**Amended Concept Development Application (SSD-9579) for an Over Station Development (OSD) above the new Crows Nest Metro Station including maximum building envelopes, gross floor area, conceptual land uses, car spaces and signage zones.**

**Submission by Wollstonecraft Precinct Committee (Preliminary)**

**2 WEST ELEVATION - PACIFIC HIGHWAY**  
1 : 1500

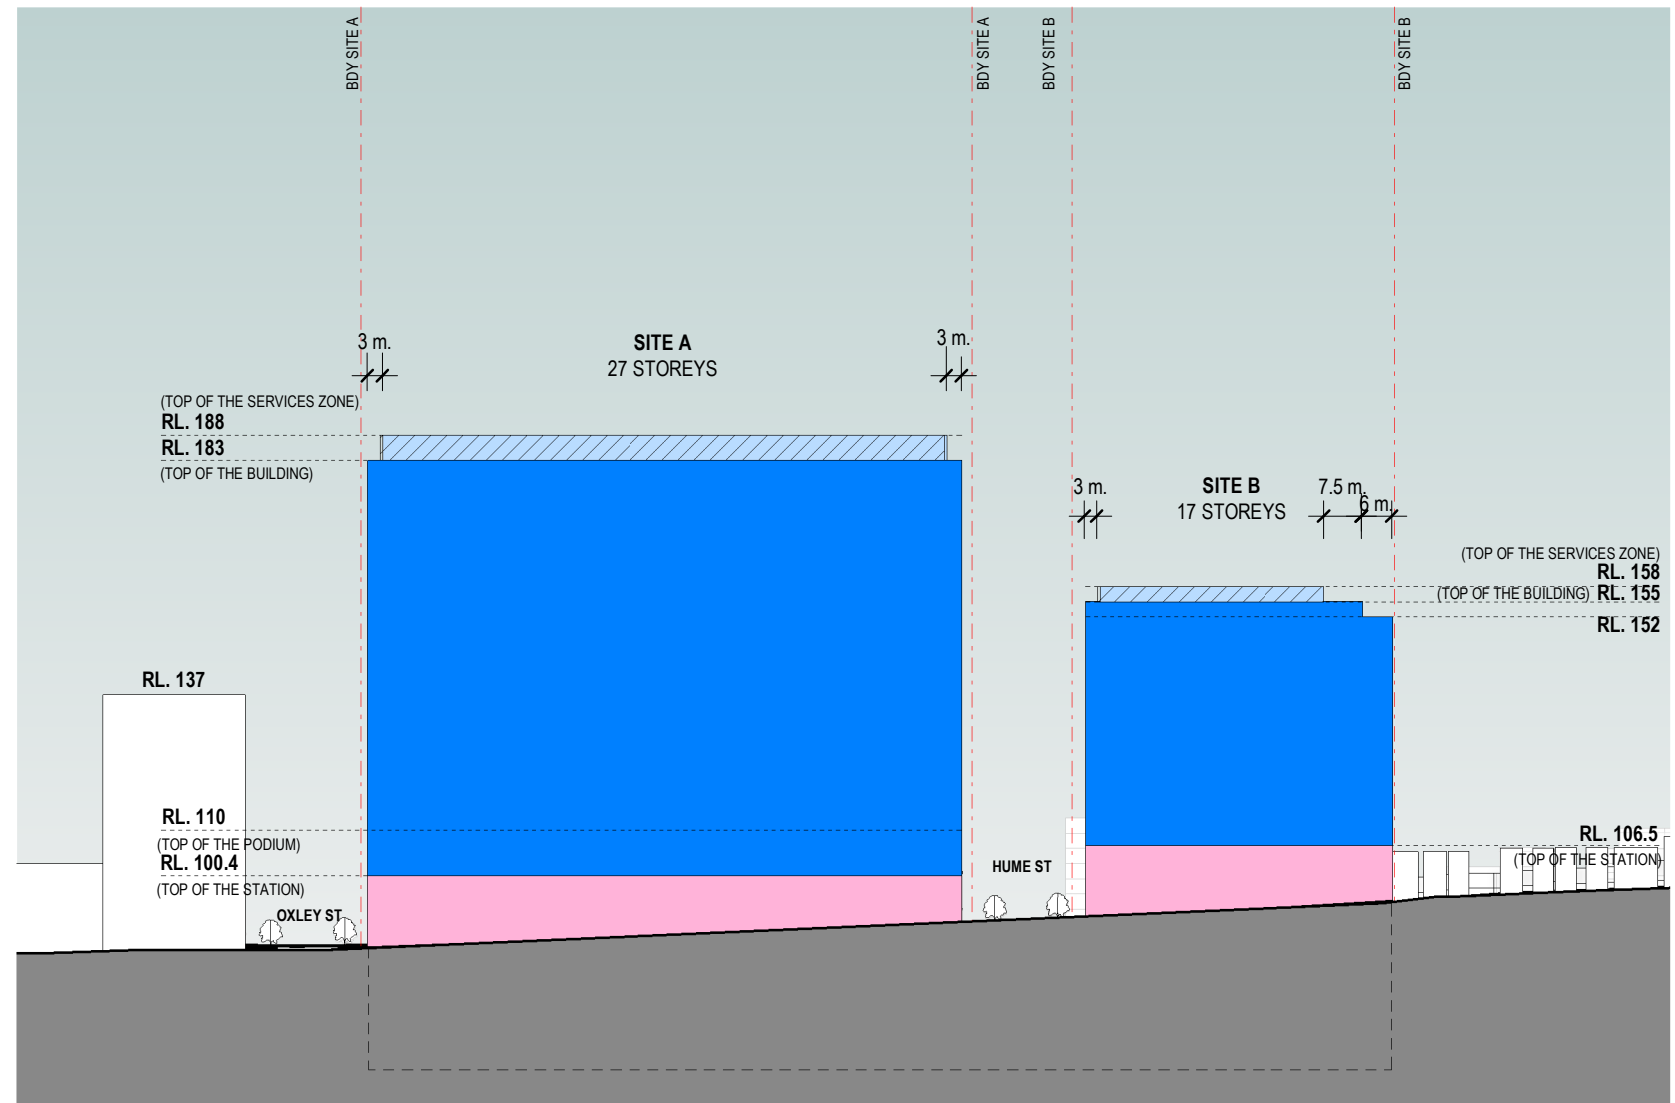
It is acknowledged that the new commercial office building on Site 'A' has a changed envelope, but the 20% reduction is misleading. The envelope ignores the fact there were originally two towers proposed on this block with a large gap between.

Taking into account the net area of the western faces, the commercial office building even with the steppes towards the south, is only 6% less than that of the twin towers. Hence its bulk and scale will be a blot on the landscape and will forever block out sky views as well as reducing solar access. It will be entirely out of context with the low rise suburb of East Wollstonecraft and the Crows Nest village.

The shadow diagrams for this building, ignore what will now be a future 24 storey mixed use/residential development on the opposite side of the highway. Shadows from that development in the afternoon will eliminate the effect of the stepped face of the OSD building A and as a result worsen the effect of shadowing to Willoughby Road.

Figure 6A: Proposed Crows Nest OSD building envelopes – west elevation (Pacific Highway)

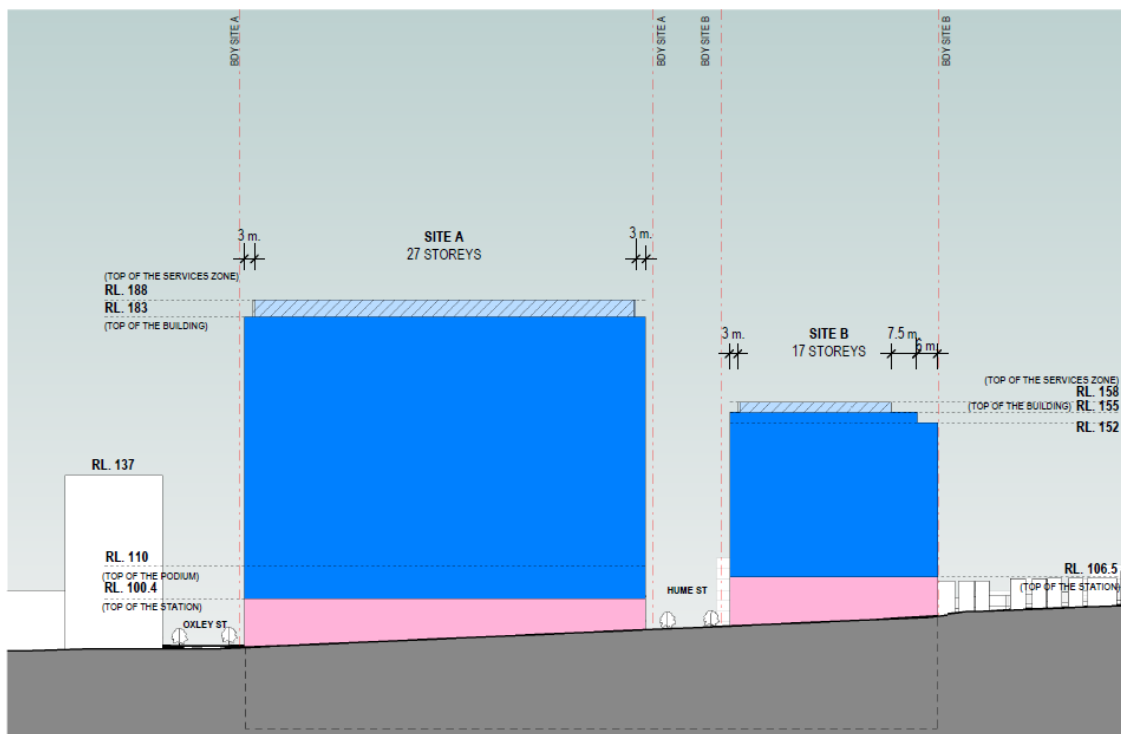
The two images are shown at different scales which gives a misleading impression that the amended project is very much smaller than originally exhibited. Yet, the only material change to the envelope is a height reduction of 7.6 metres to Building A and a truncation of the south face, offset by elimination of the large vertical gap between the two towers as originally exhibited. According to Sydney Metro this envelope is 20% less than the original proposal. However, it is one building, not two and will be a very imposing frontage over the full block. In reality its bulk is reduced by 6% not 20%.

The claimed 20 percent reduction in the building envelope is challenged as being misleading because it ignores comparison of the net area of the east west faces of the commercial building on Site A with the same faces of the residential building as originally exhibited. Our conservative analysis is shown on Attachment 'B'. The summary is as shown below:
